Conservatory to rear. This application may affect the setting of a listed building & affects the character & appearance of the East Street, Littlehampton Conservation Area.

Lion Cottage 57 East Street Littlehampton

Thank you for your internet representation made on 3rd June 2019 which has been recorded as '**an objection**' with the comments as follows:

CONSERVATORY DESIGN

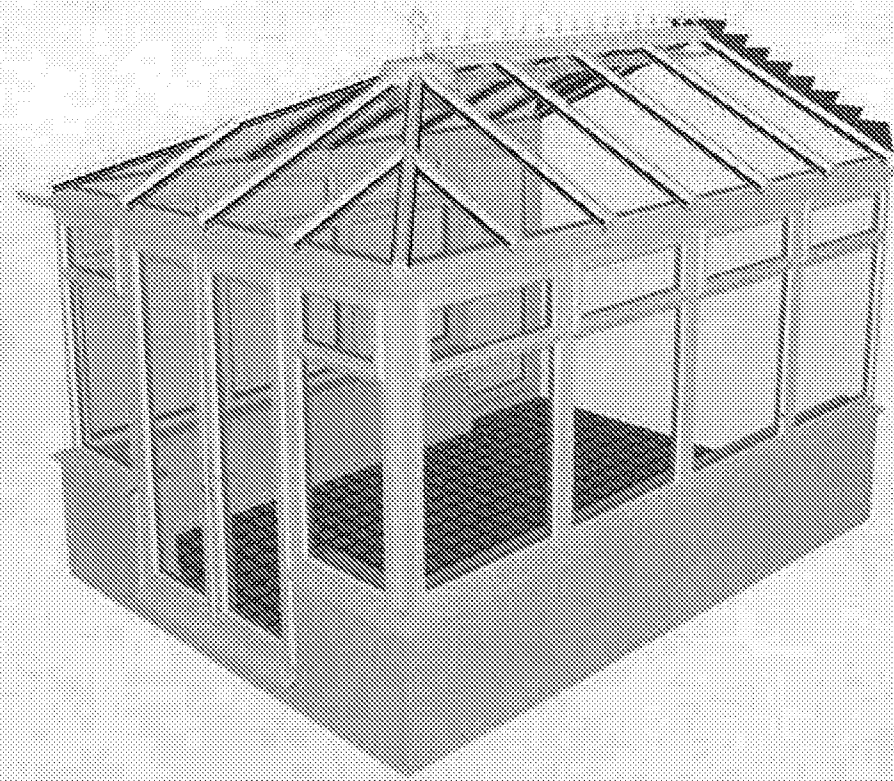
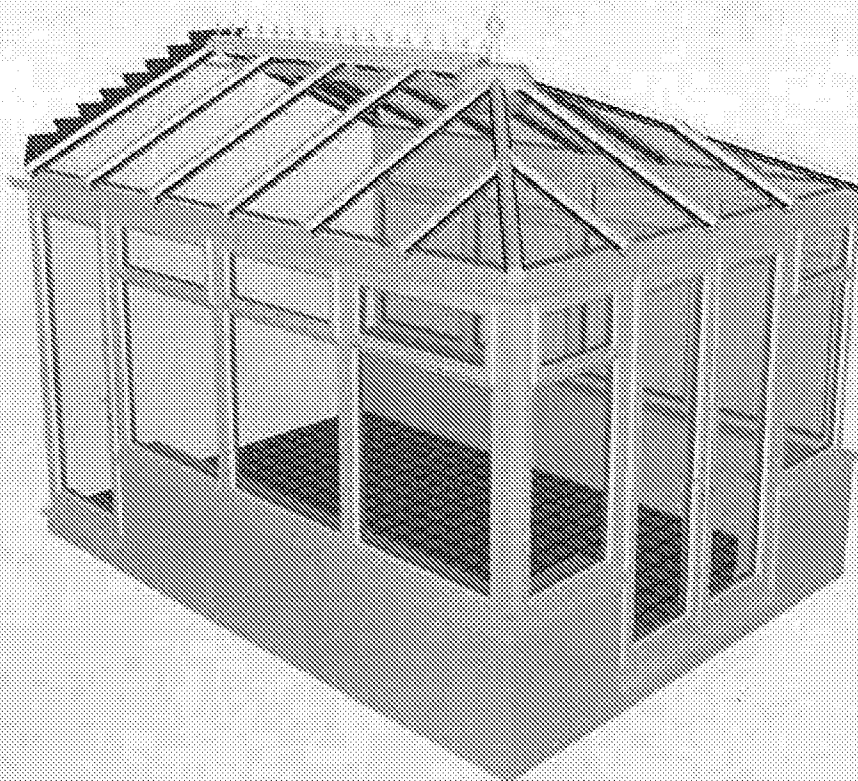
The proposed conservatory will be partially seen from the Green Lady and as such the introduction of PVCu will have an adverse impact on the conservation area. It is strongly recommended that either powder coated aluminium or painted timber be used instead of PVCu. Suitable colours also need to be considered.
